WEST SUSSEX COUNTY COUNCIL CONSULTATION

TO:	Arun District Council FAO: Anita Gardner
FROM:	Highways, WSCC
DATE:	9 th January 2019
LOCATION:	Land Adj Unit H21, Rudford Industrial Estate, Ford Road, Ford, Arundel, BN18 0BD
SUBJECT:	CM/39/18/PL Change of use of land to open storage (B8 Storage or Distribution).
RECOMMENDATION:	☐ Advice ☐ Objection ☐ Modification ☒ No Objection ☐ More Information ☐ Refusal
S106 CONTRIBUTION TOTAL:	£N/A

SITE PLAN

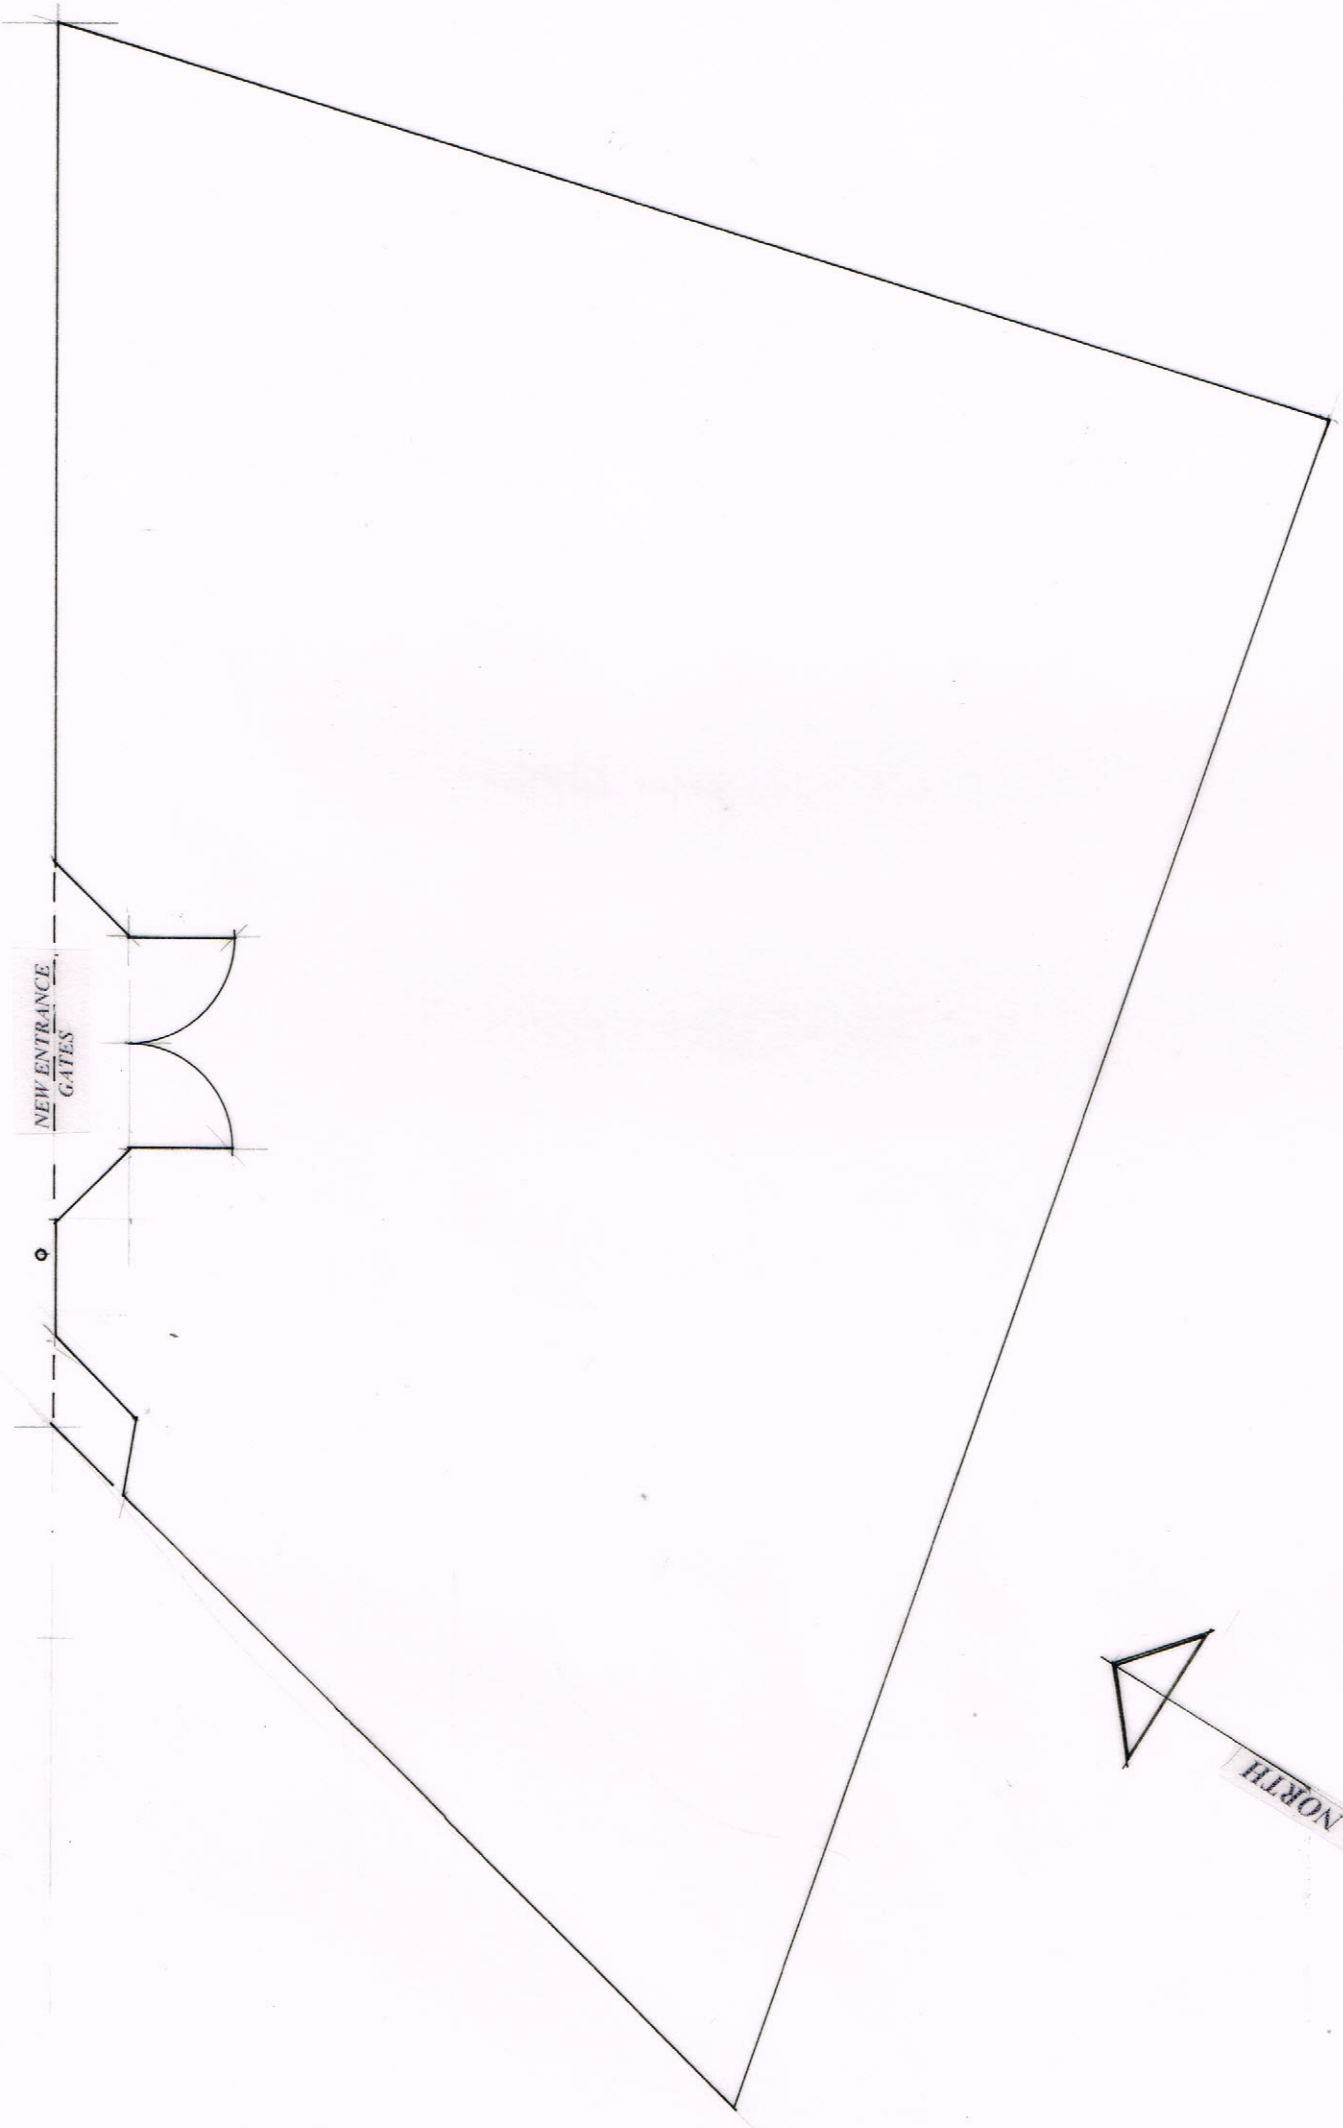
No parking exists within the site which will be wholly open storage use. Staff parking will take place on adjacent estate roads as per existing scenario. It is not clear whether the vehicular access to the site exists though from an inspection of local mapping access would be through a car parking layby. No detrimental impact on the nearby *publically maintained* road network is anticipated as a result and vehicle speeds along the private service road are anticipated to be low. Any new access point onto the road should gain the permission of the proprietor of the private service road.

Whilst vehicle access into the site has not been demonstrated via swept path tracking the LHA considers there is sufficient space within the access and site for vehicles to turn and vehicles would continue to exit to Ford Road in a forward gear.
